Littlehampton Harbour Board
Harbour Office,
Pier Road
Littlehampton
West Sussex
BN17 5LR

Our Ref: 3709

23 March 2021

I am writing to you after noticing your Planning Application to Arun District Council for establishing a timber jetty on the river (ref AB/14/21/HH). As I hadn't yet heard from you directly on the proposal, I just wanted to write to ensure you are aware of the following additional licensing requirements for marine works which are explained further at <https://www.littlehampton.org.uk/environment/marine-licensing/> and on our attached guidance document. Please note that it would appear you also require the following (in order) because the project includes works in the river within the high water springs line,

JETTY
PROPOSED SITE LAYOUT

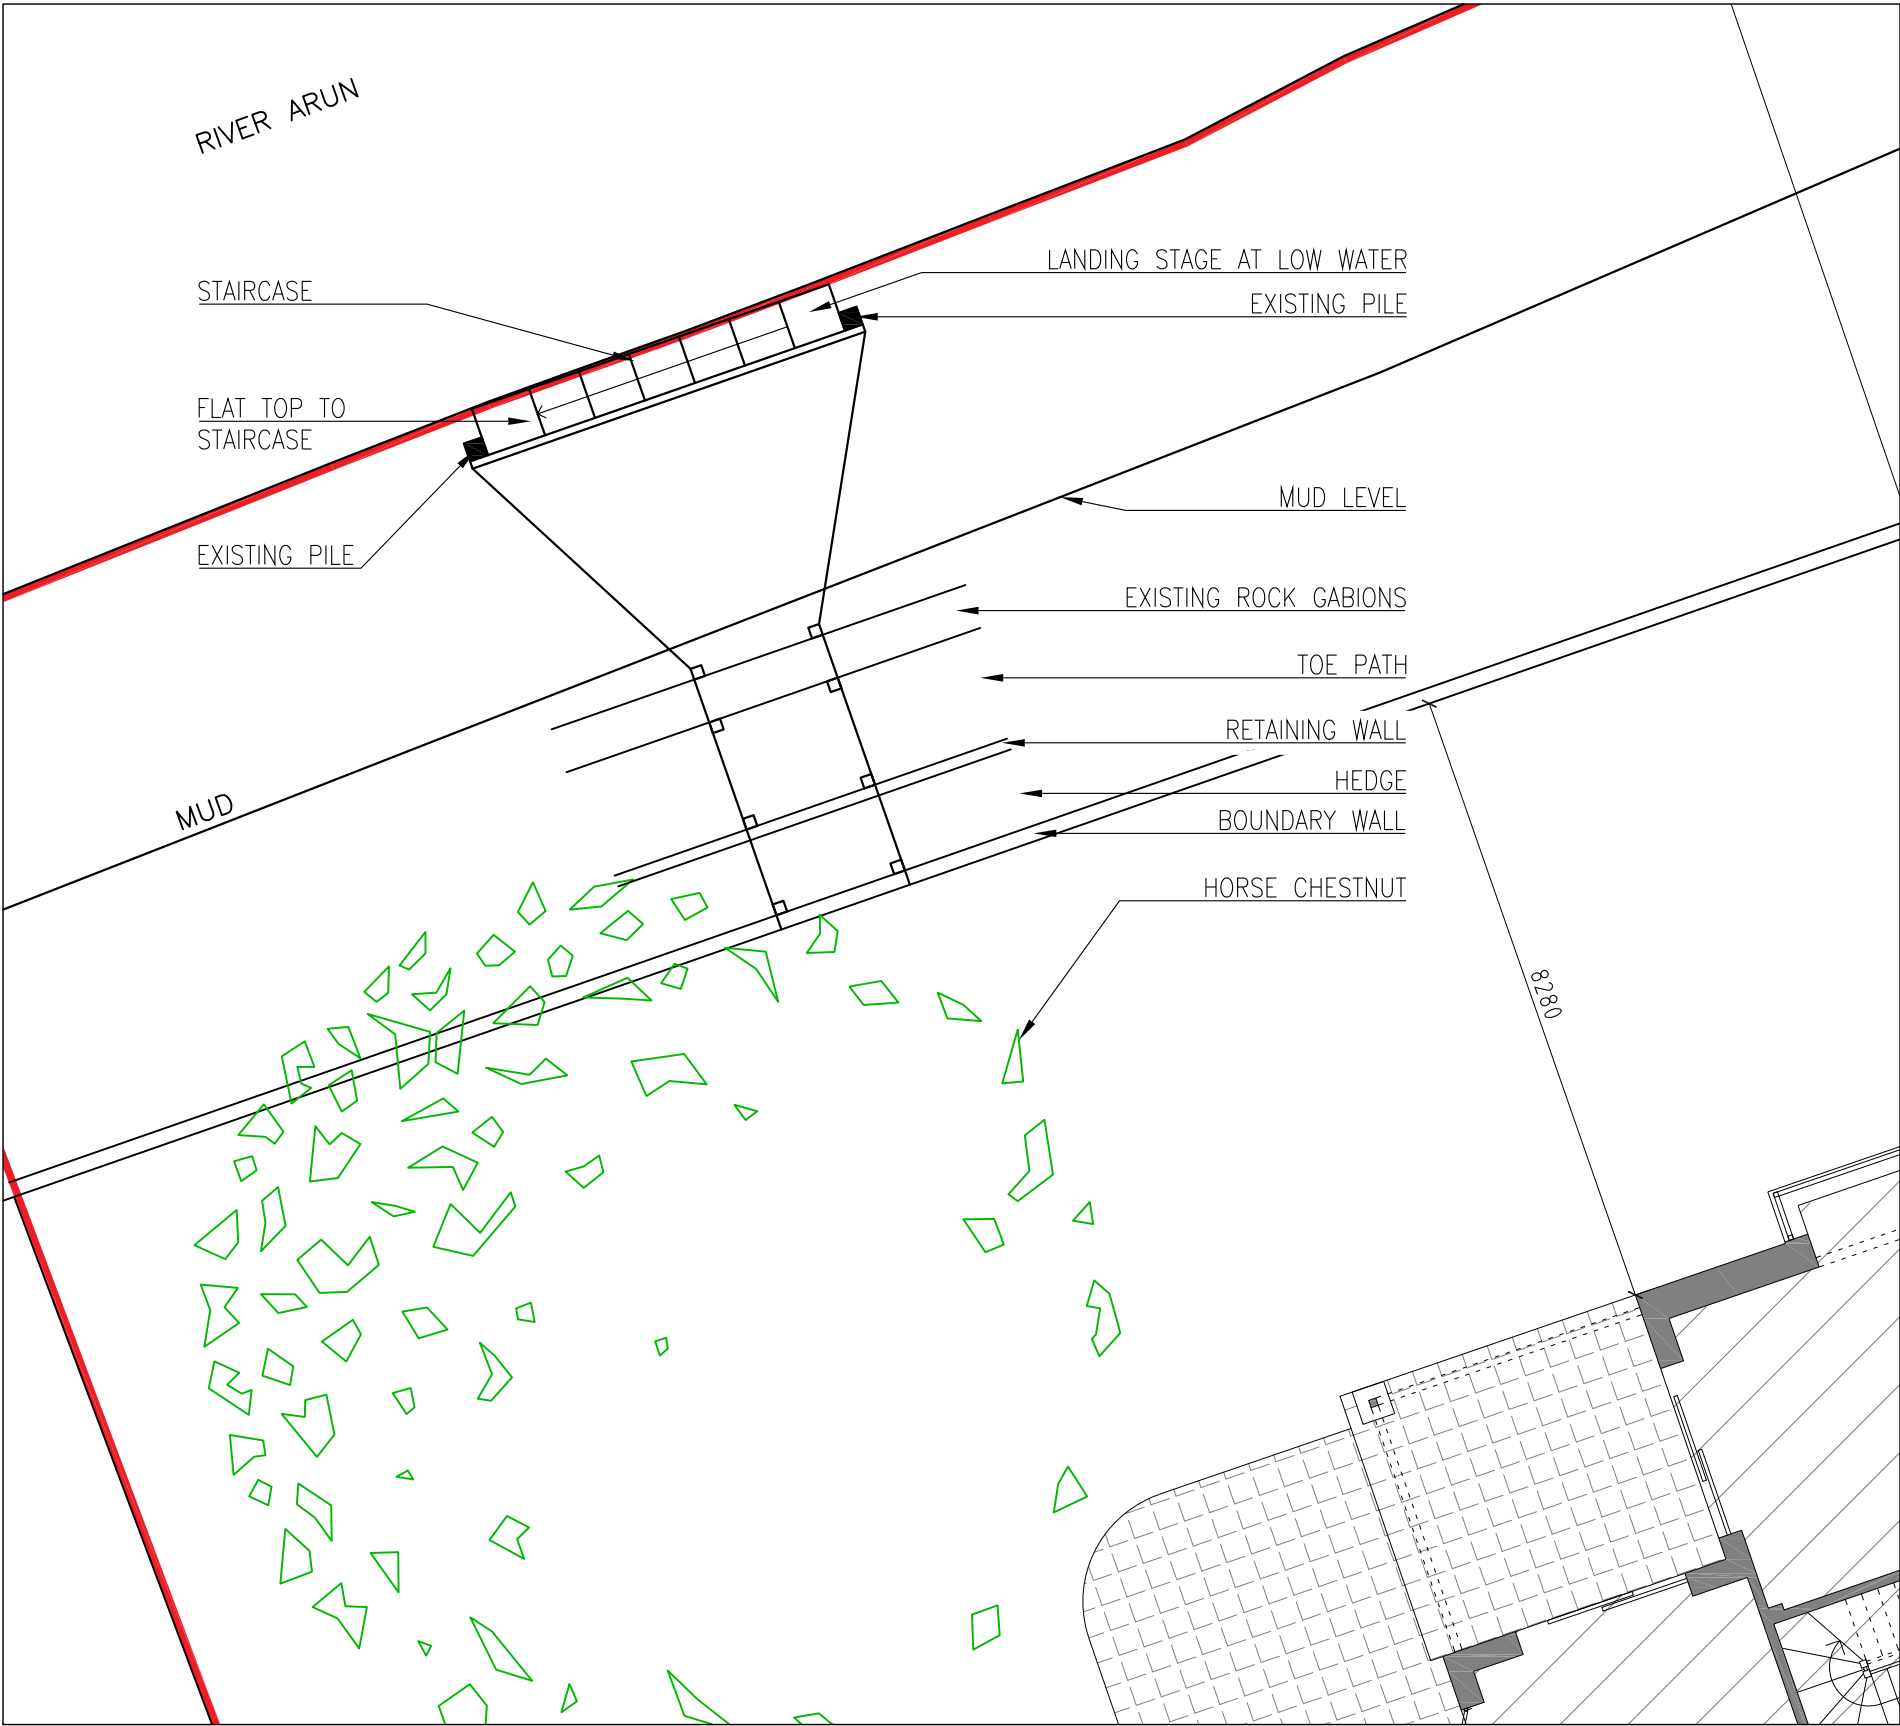
Generally, I and the board are very supportive of additional moorings on the river but I will need to take a more detailed look at your proposals due to their proximity to the area where visiting craft turn on arrival or departure at the opposite Arundel visitors pontoon. The tide runs swiftly through this area as you will be aware and turning around here is already challenging. If the channel is narrowed here, boats will need a few extra points in their multiple-point turns and will be carried along sideways further by the flooding tide towards the hazardous width and height restriction of Queens St bridge. If the proposals are to be consented to, careful consideration will need to be given to mitigating the additional risk to craft here including direction on safe mooring arrangements for vessels on this jetty once established (e.g. a very wide vessel would create an even greater channel restriction).
